Alexandria Park Community School Redevelopment Submission

I am writing to make objections to the significant development application SSD 8373 for Alexandria Park Community School, Park Road, Alexandria. The proposed Alexandria Park Community School (APCS) redevelopment is out of character for the neighbourhood and will adversely affect the village atmosphere of Alexandria and its residents. It will especially impact the life of the people that live in buildings immediately adjacent to the redevelopment. Therefore I am objecting to the redevelopment for the following reasons:

ELEVATIONS AND SECTIONS

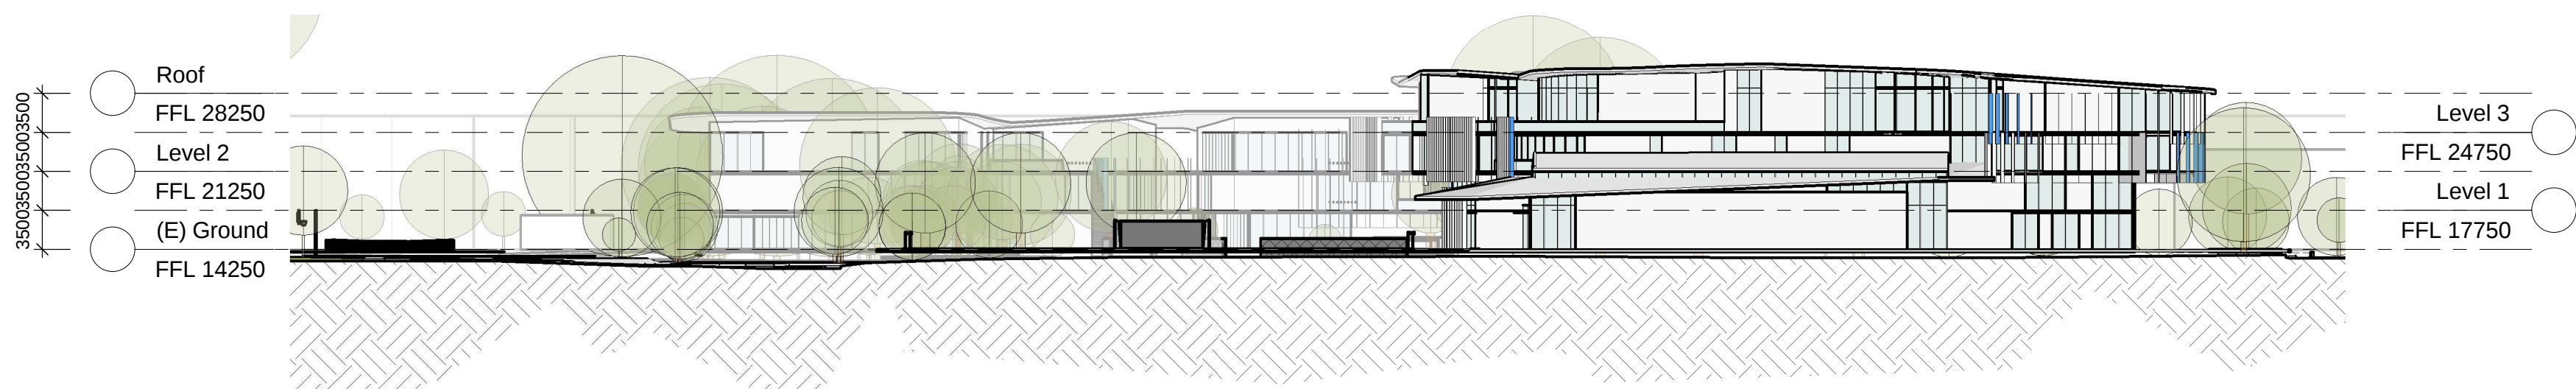
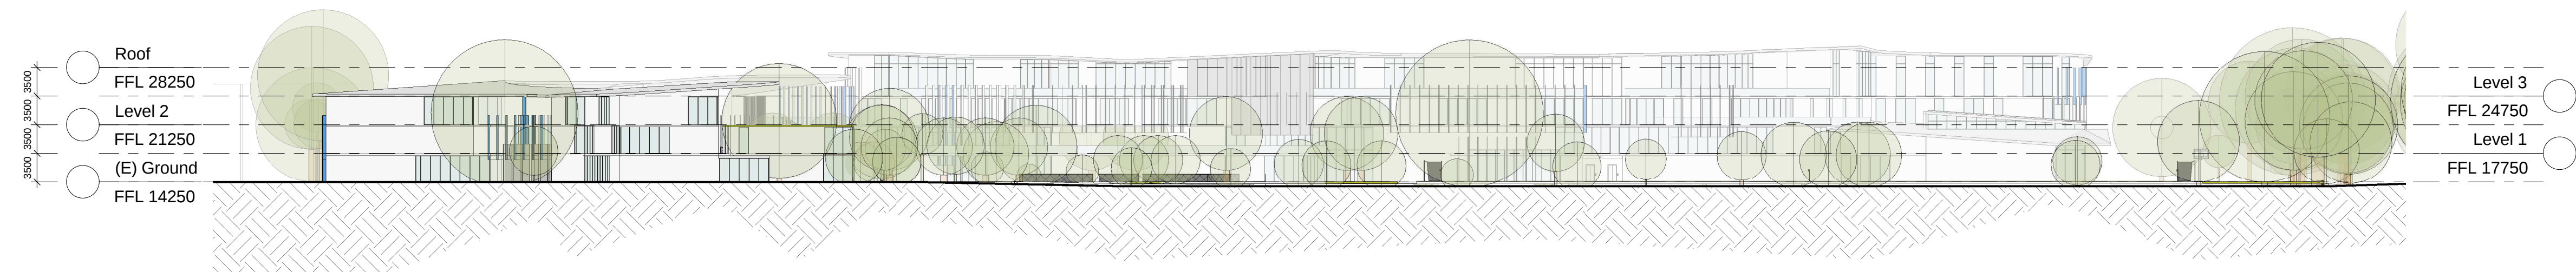
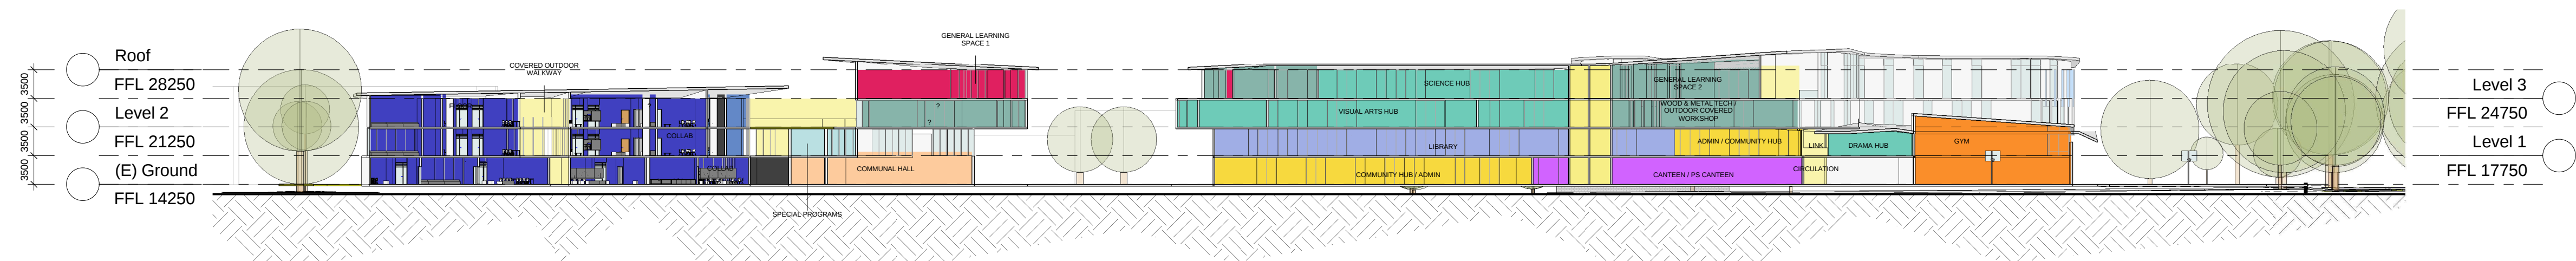
This proposed redevelopment makes very little attempt to integrate with the surrounding buildings by exceeding the Sydney City Council's height restrictions by 6 or more metres (please see attachment). The buildings immediately adjoining meet the council restrictions of 15 metres with flat roof lines. Other buildings on Wyndham Street and Power Avenue also meet these same restrictions by not exceeding 15 metres. While the buildings on Buckland Street meet the restrictions of 9 metres height limit. The APCS redevelopment exceeds these limits by about 6 to 12 metres.

The redevelopment of APCS should be required to adhere to height restriction of 15 metres for the area with flat roofs that have solar panels with a angle of no more than 10 degrees from the horizontal (this would also maximise sun exposure).

WINTER SOLSTICE 9AM

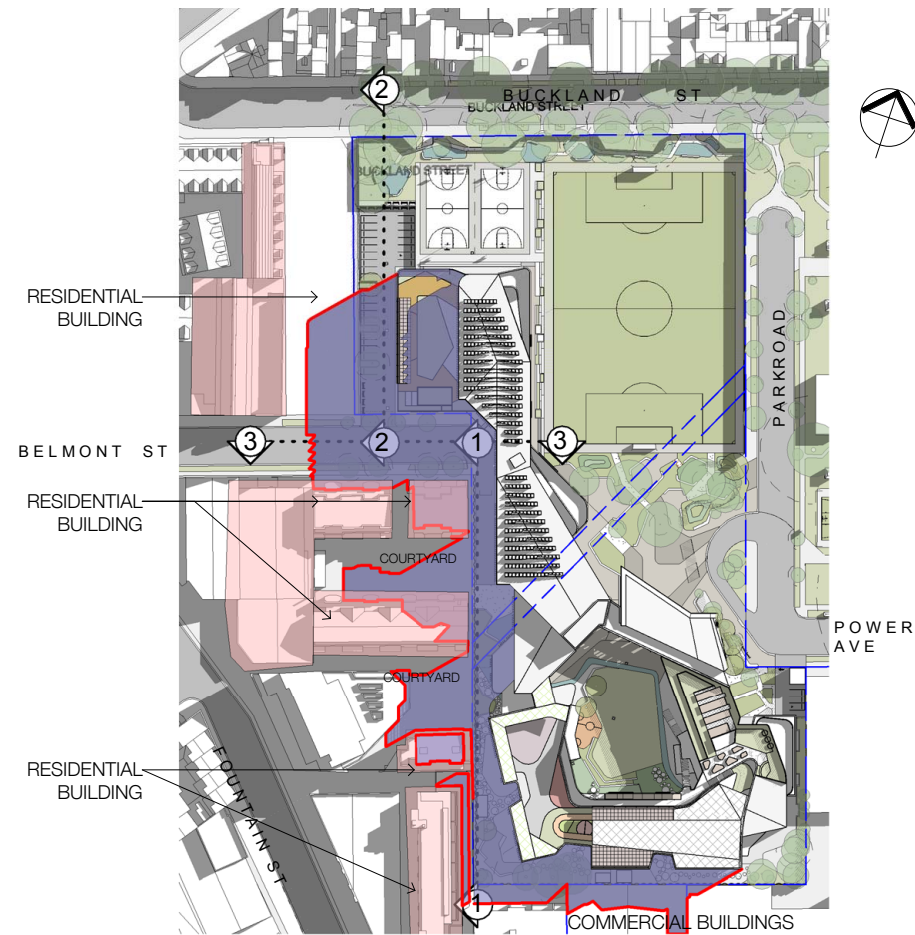
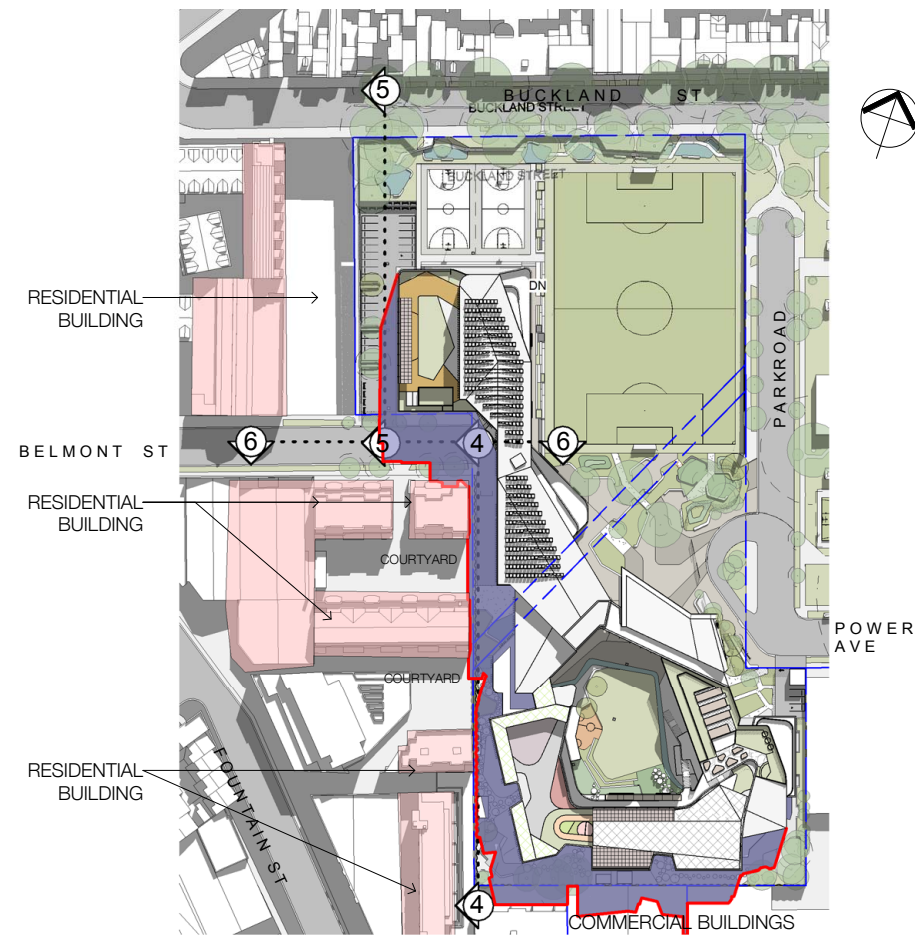
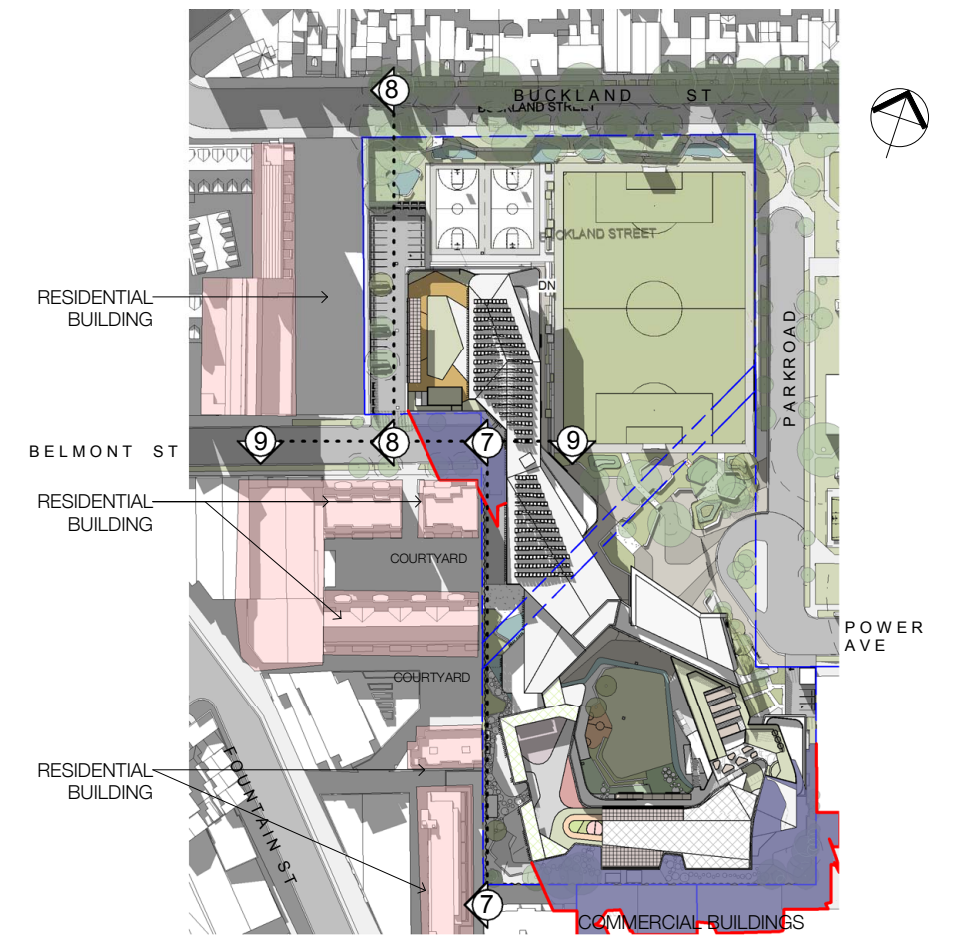
The APCS redevelopment will reduce the light and sunlight entering the adjoining buildings by shadow the buildings on Belmont Street and Fountain Street especially during the winter solstice. This will also reduce light and sunlight entering principle living spaces adversely impacting residents and the sustainability benefits of these buildings during the winter months due to the reduction of winter sun.
